Re: Response to El Paso County Review Comments
Monument Ridge East
Monument Hill Road and Palmer Divide Road
El Paso, Colorado
Entech Job No. 230248

Ref: Entech Engineering, Inc., revised date July 16, 2026. *Soils and Geology Study, Monument Ridge East, Monument Hill Road and Palmer Divide Road, El Paso County, Colorado.*
Entech Job No. 230248.

Entech Engineering, Inc. (Entech) has reviewed the El Paso County review comments dated August 6 and 12, 2026 on the proposed Monument Ridge East development. This letter presents our responses to the El Paso County comments. It should be noted that additional investigation/design will be required and completed as the project continues through the development process.

Exhibit 1: Temporary Piezometer Measurements – Monument Ridge East

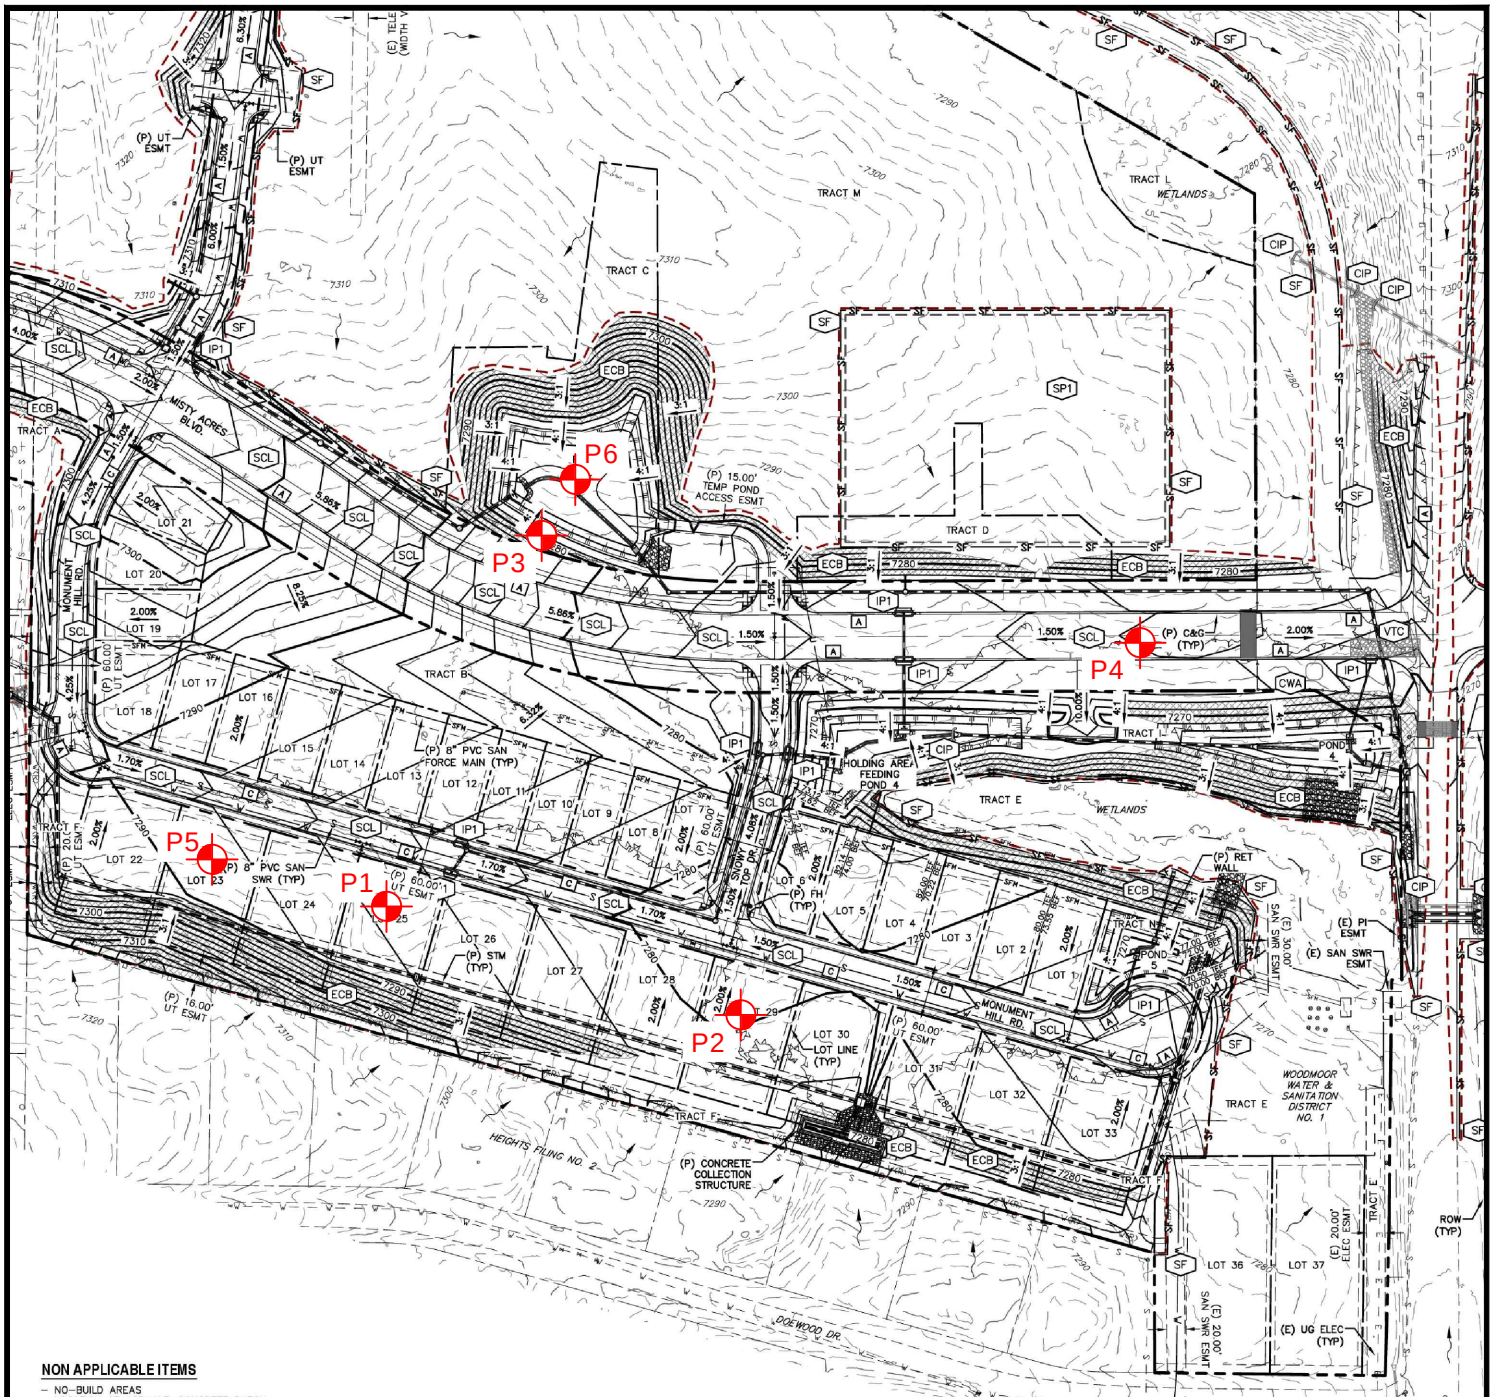
When will groundwater be determined for construction? Will testing be done prior to construction, early grading, or during construction? If groundwater is encountered within 5 vertical feet of public ROW or drainage facilities, additional reports and testing will be required to address shallow groundwater. (See ECM C.6.1)

- It is our understanding that underdrains will be installed on the site. In areas where water is in close proximity to foundation grade additional drains will be required. Drain details for underslab and interceptor drains have been included in the Soils and Geology Study.
- Entech will continue to monitor the temporary piezometers throughout the coming seasons and during the development process. Additional site subsurface investigations will be performed as development is completed. Additional piezometers will be completed as needed.

Entech installed two additional piezometers on July 21, 2026 (P5 and P6). P5 was placed on proposed Lot 23, and P6 was placed in the bottom of Pond 2. The locations of the piezometers for the site are shown in the Piezometer Map, Figure 1. The test boring logs for the two additional piezometers are included in Appendix A, and Laboratory Testing Results are included in Appendix B. Piezometer readings for the development are included in Exhibit 1.
